ARCHITECTURAL DESIGN REPORT - ADDENDUM 01

The New Primary School in Mulgoa Rise

APPLICATION NO. SSD-11070211

Drawing Title
SITE SECTIONS

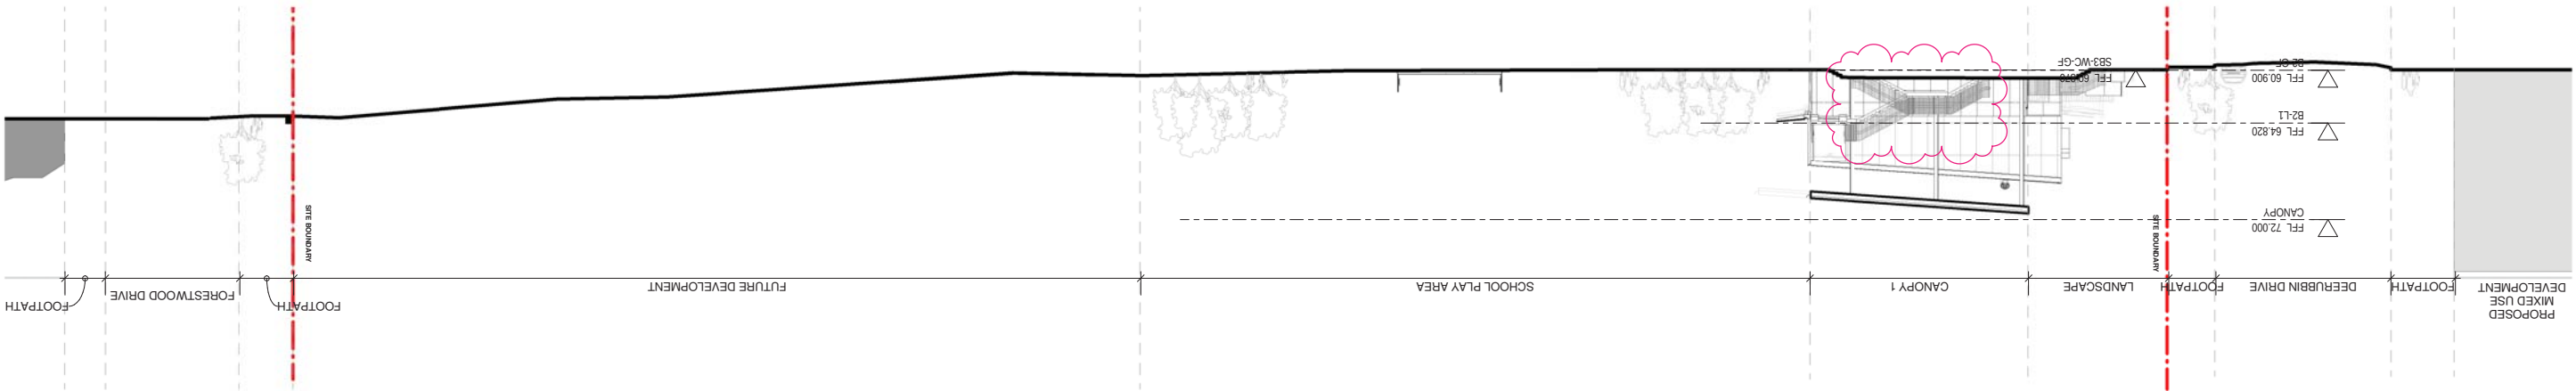
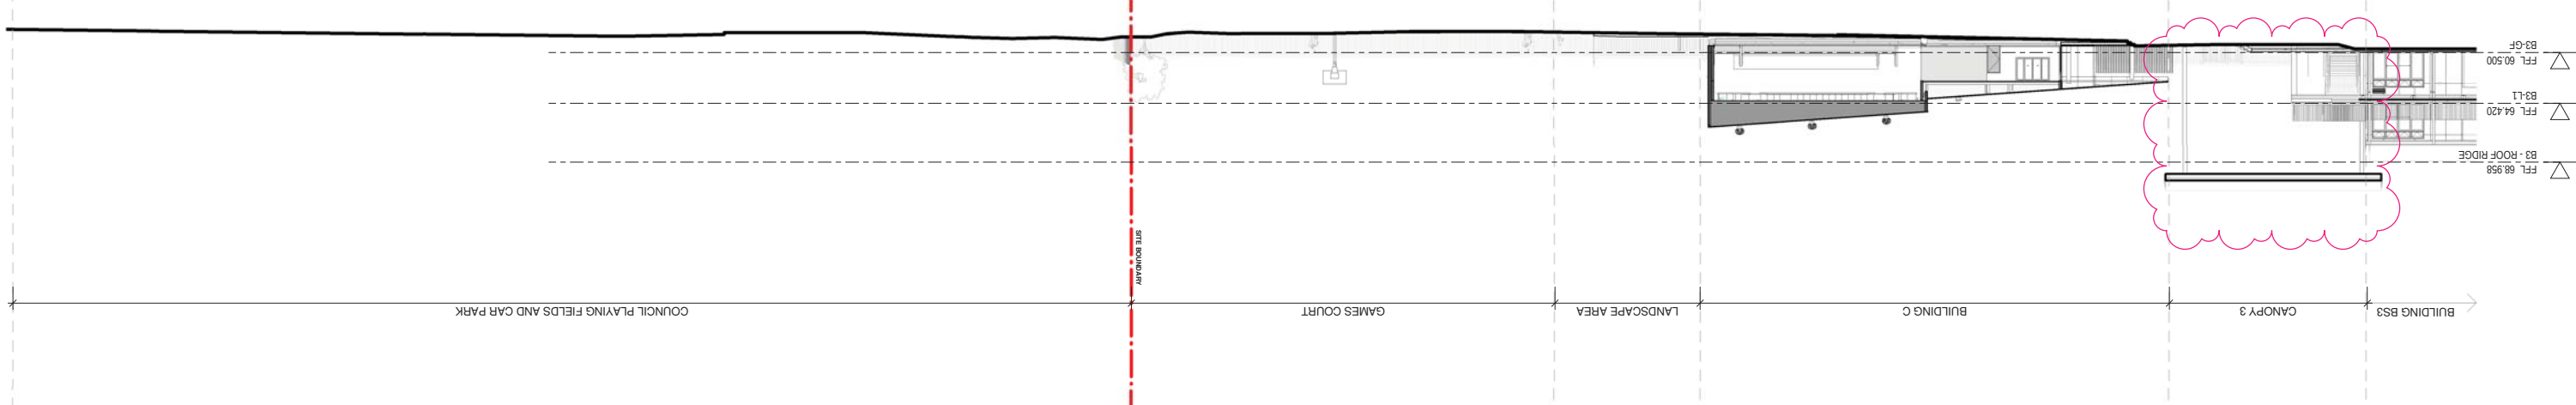
A large wall has been created to divert water around the site to avoid flooding. Transform this wall into public amenity, for example by incorporating a pocket park, WSUD strategies, seating and gathering spaces.	More intensive landscaping is proposed to soften the appearance of the diversion wall. Public amenity in the form of a pocket park or otherwise is not the responsibility of SINSW.
	Architecture	Further resolution and development is required in relation to: a) A colour palette that is reflective of the local landscape and context and will withstand the effects of the local microclimate. This is an opportunity to introduce Connecting with Country principles into the design. b) The detailing and material character of the buildings lacks elegance and requires further detailing. c) Develop a sun shading strategy that demonstrates thermal comfort will be achieved, and that also improves the character and articulation of the facades.	a) Since the SDRP presentation the colour palette has been updated to reflect earthy tones in reference to nearby mountains, rock formations and the historic quarry. The finish of the materials is unreflective and highly durable. Combined with the proposed insulation, the building envelope will be well suited to withstand the microclimate experienced in this area. The current design is appropriate for the characteristics of the local microclimate. The design, colour palette, materiality and response to microclimate is subject to Connecting with Country. b) The materiality and detailing of the buildings have been selected for their durability, robustness, compliance, and cost, all explored through a detailed value management process undertaken by the design team and SINSW stakeholders. A mix of CFC cladding, metal cladding and add-on elements are proposed on this project in a cost-efficient assembly. Articulation of the façade is mainly expressed through the coloured sun hoods and can be further achieved through use of colour – an agenda item for Connecting with Country consultation. Refer to updated elevations and detail sections in the architectural drawing package.

Drawing Title
BUILDING C - ELEVATIONS

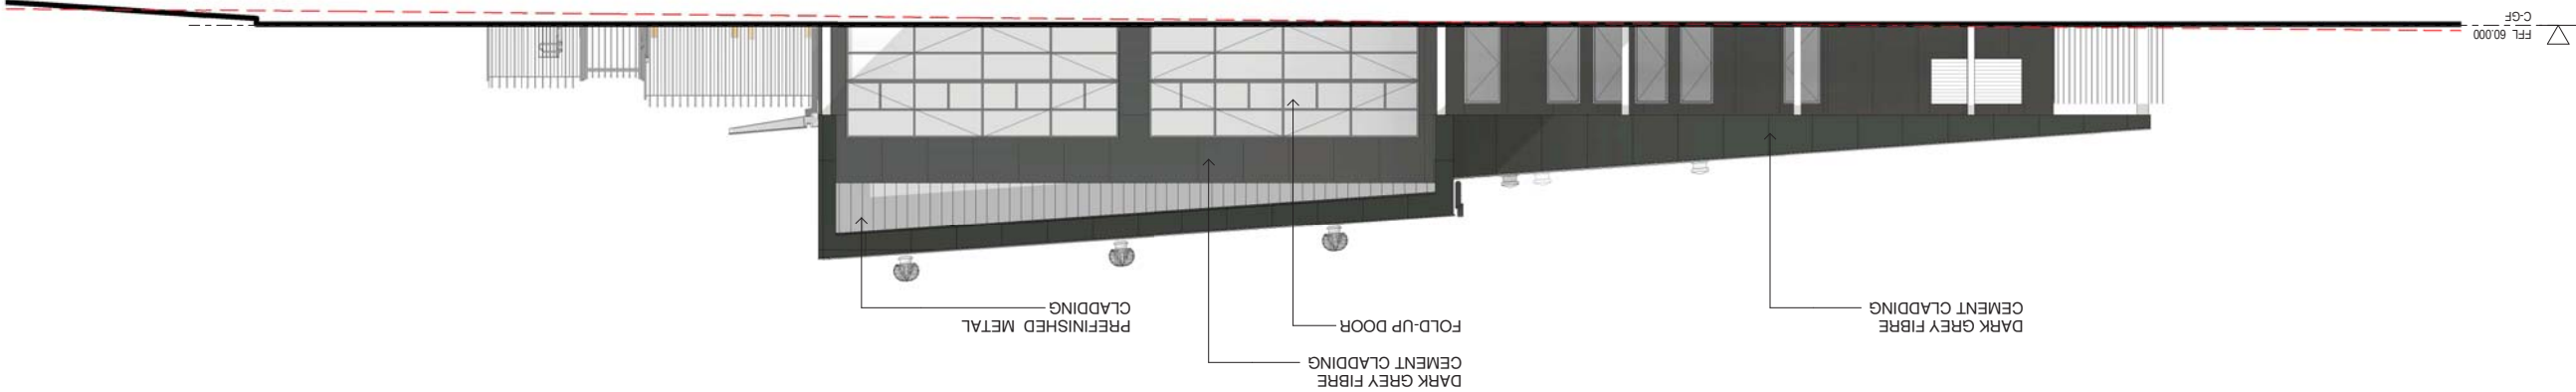
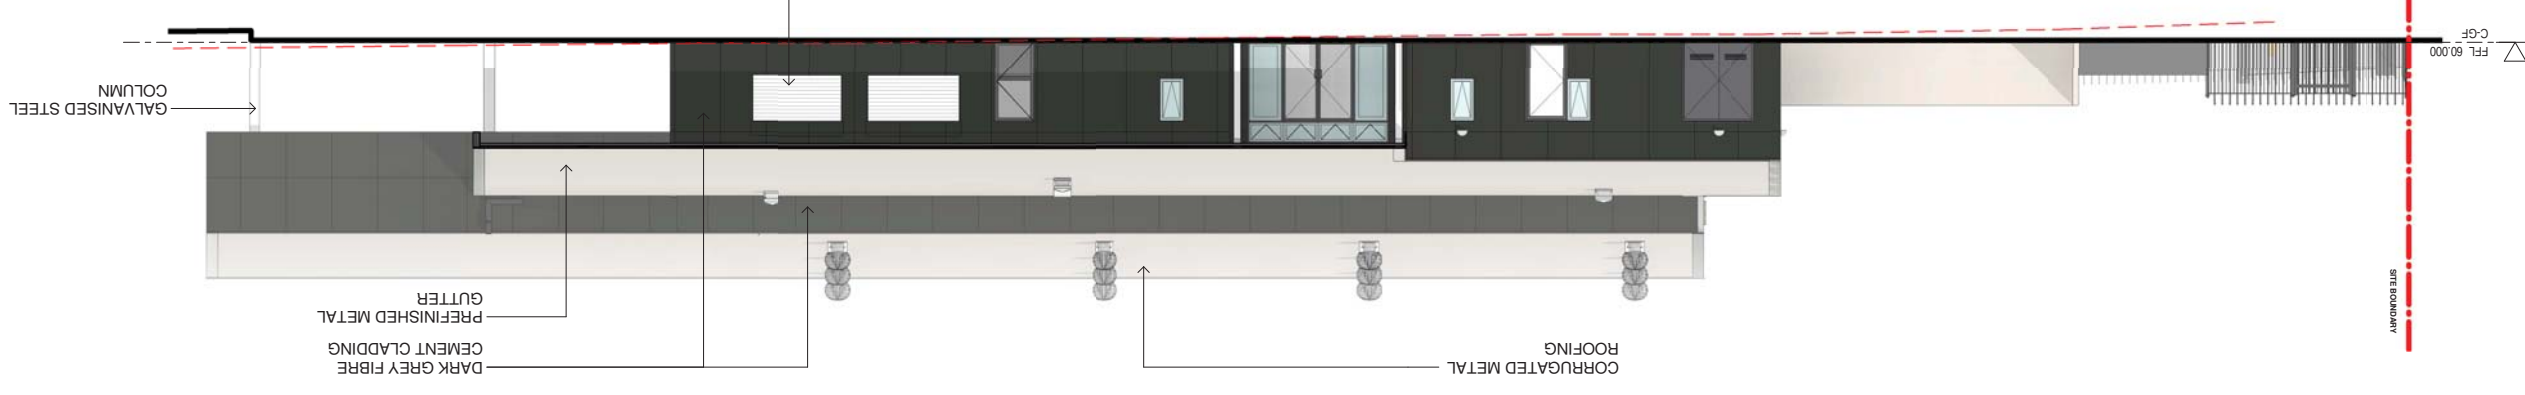
- (1) The COLA has been relocated to the southern end of Block C to better accommodate spill over from the hall during events and together with the tiered seating provide better connection to the future sports field.
- (2) The doors on the eastern façade have been downsized and relocated for egress purposes with a sheltering awning above. External cladding was adjusted to suit.
- (3) Block C roof has been rationalised and roof pitch is now proposed at 4° throughout for better drainage.
